Application number: 2019/90541	
What is the application for?:	Erection of two storey side extension, front porch and formation of new vehicula
Address of the site or building:	6, Osborne Terrace, Batley, WF17 0LZ
Postcode:	WF17 5NN

BLOCK PLAN
SCALE 1:100

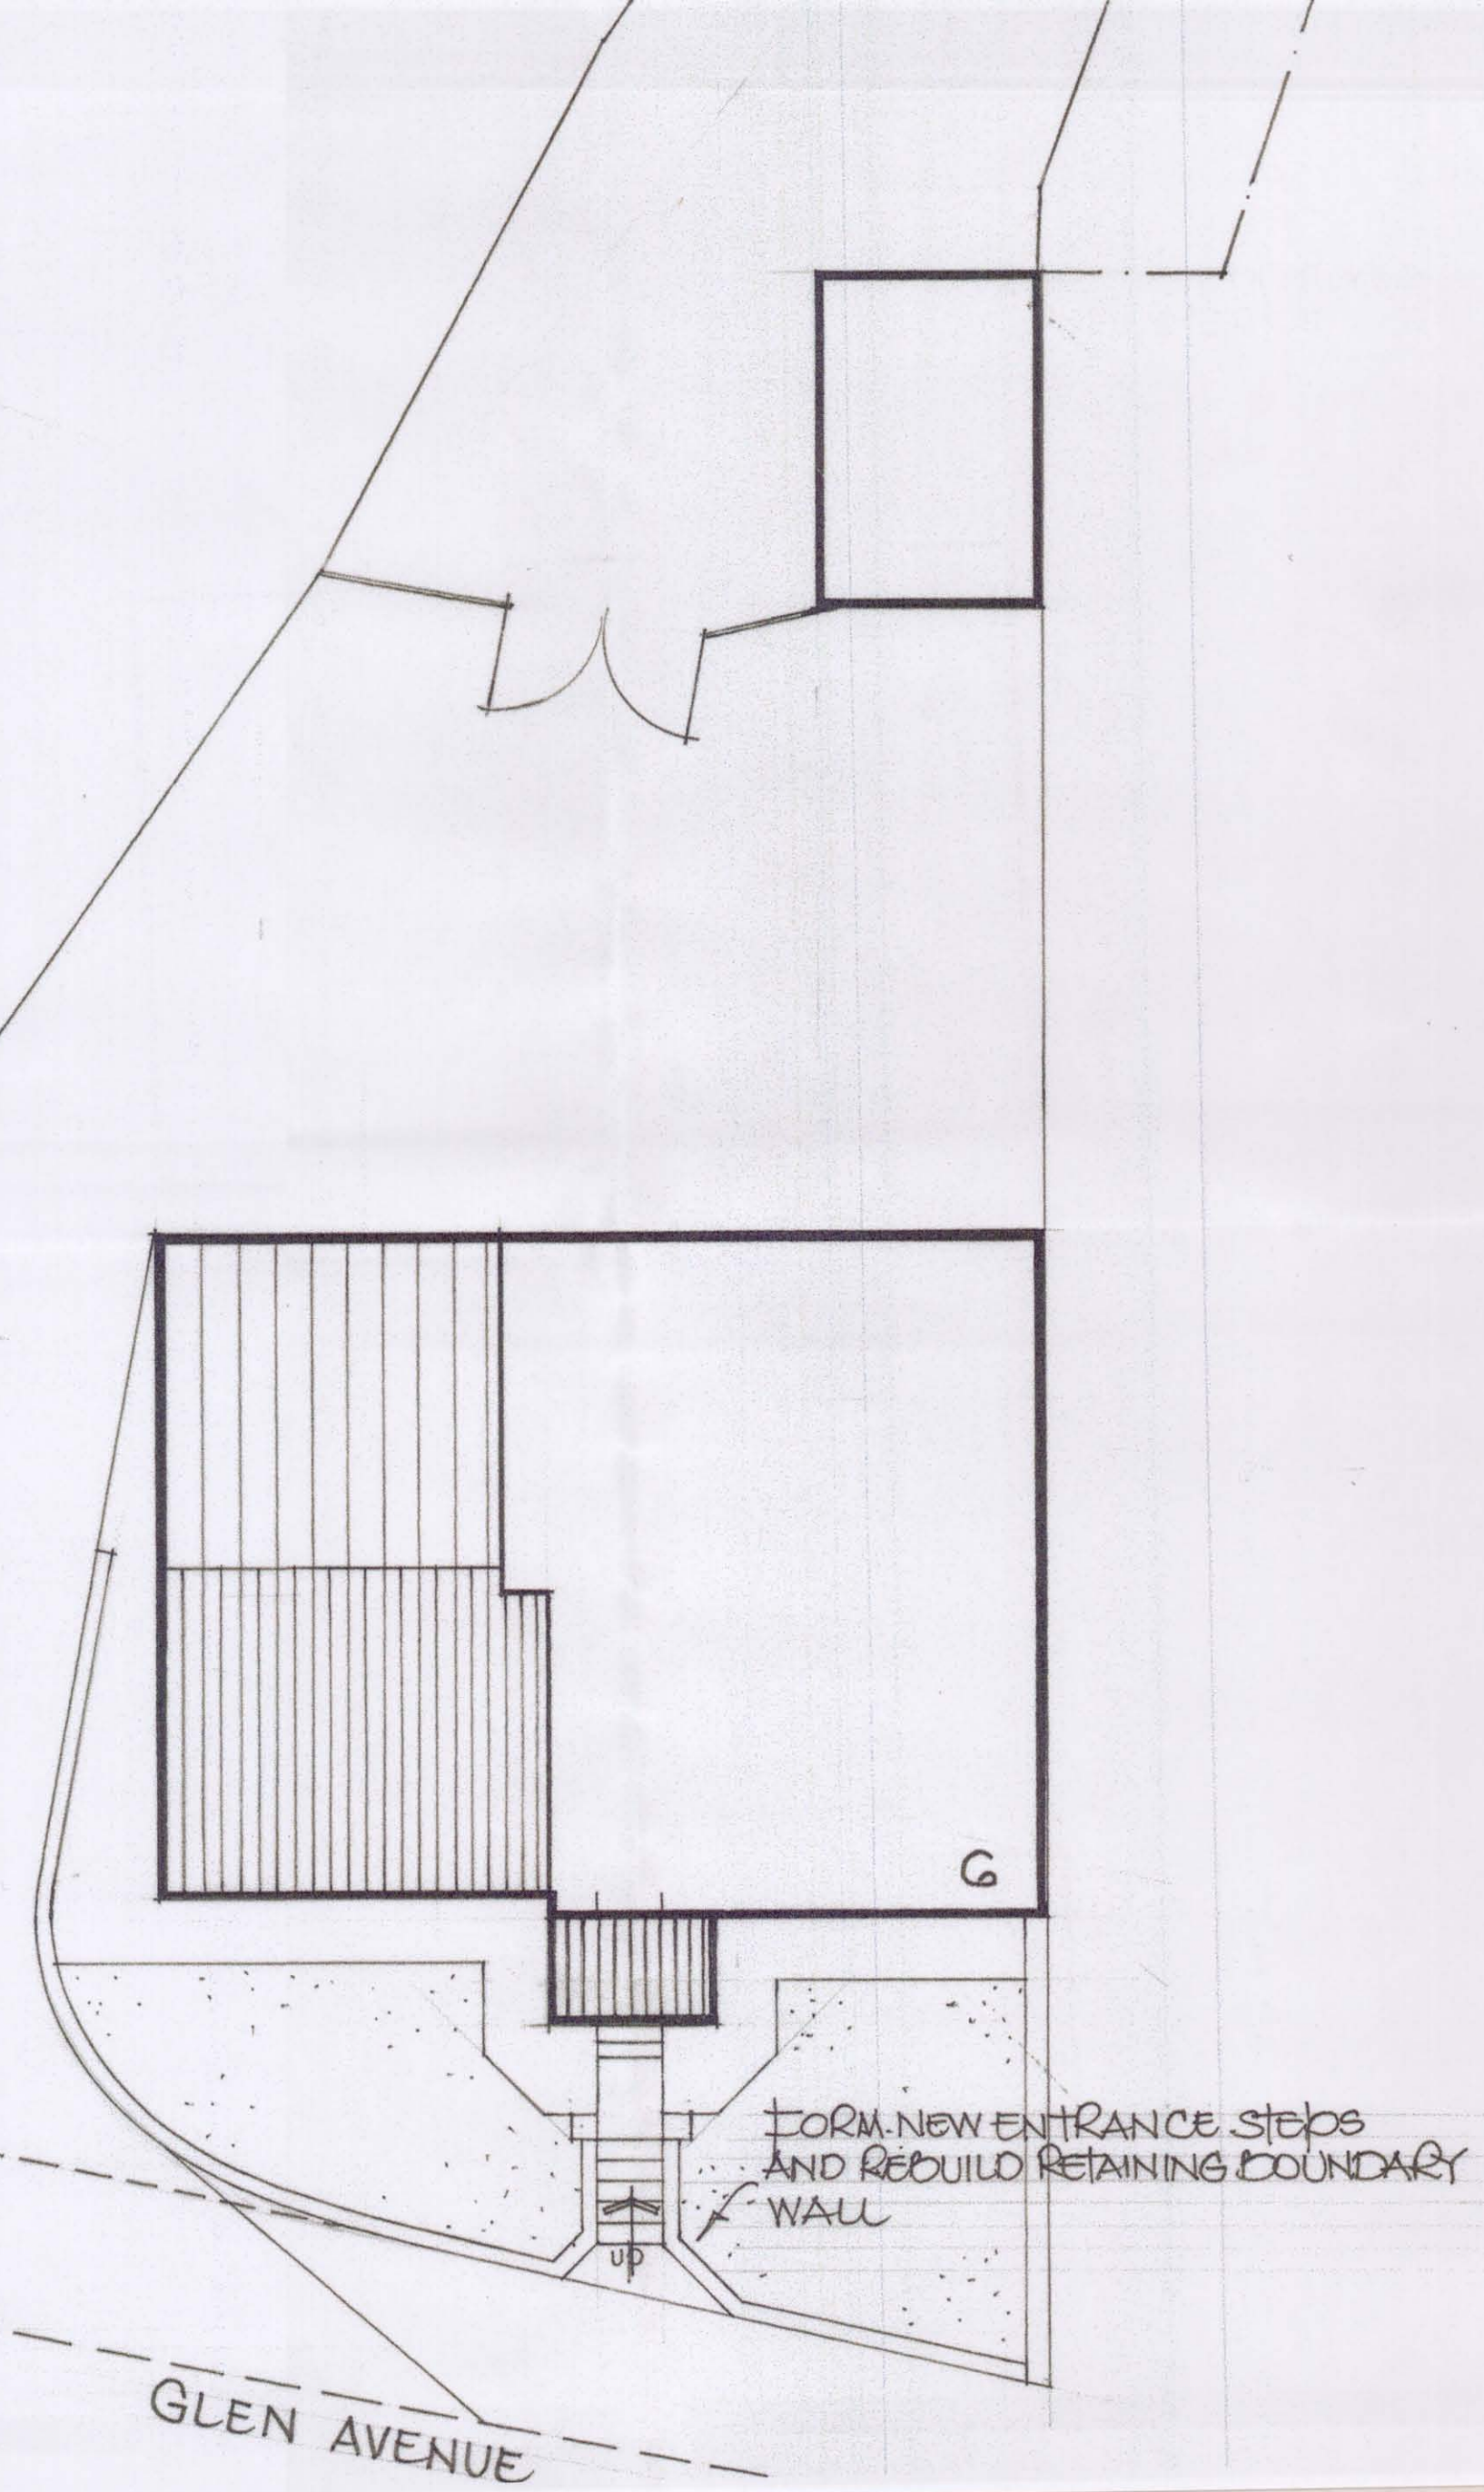
Type of comment: An objection
We would like to object to the proposed vehicular access into Wayne Close from Osborne Terrace, we see no reason for permission to be granted as there is adequate parking adjacent to the house at the rear of the property, there is also a footpath with access from Batley Field Hill running along the front of all the properties. In severe weather the residents who live in Wayne Close, have to park at the bottom as the Snow Plough doesn't go up there. I'm sure if permission is granted for one resident on Osborne Terrace to have vehicular access into Wayne Close, then it is only reasonable for any other resident to be granted access. As Osborne Terrace is within a conservation area it will alter the look and character of these Victorian Terraces.
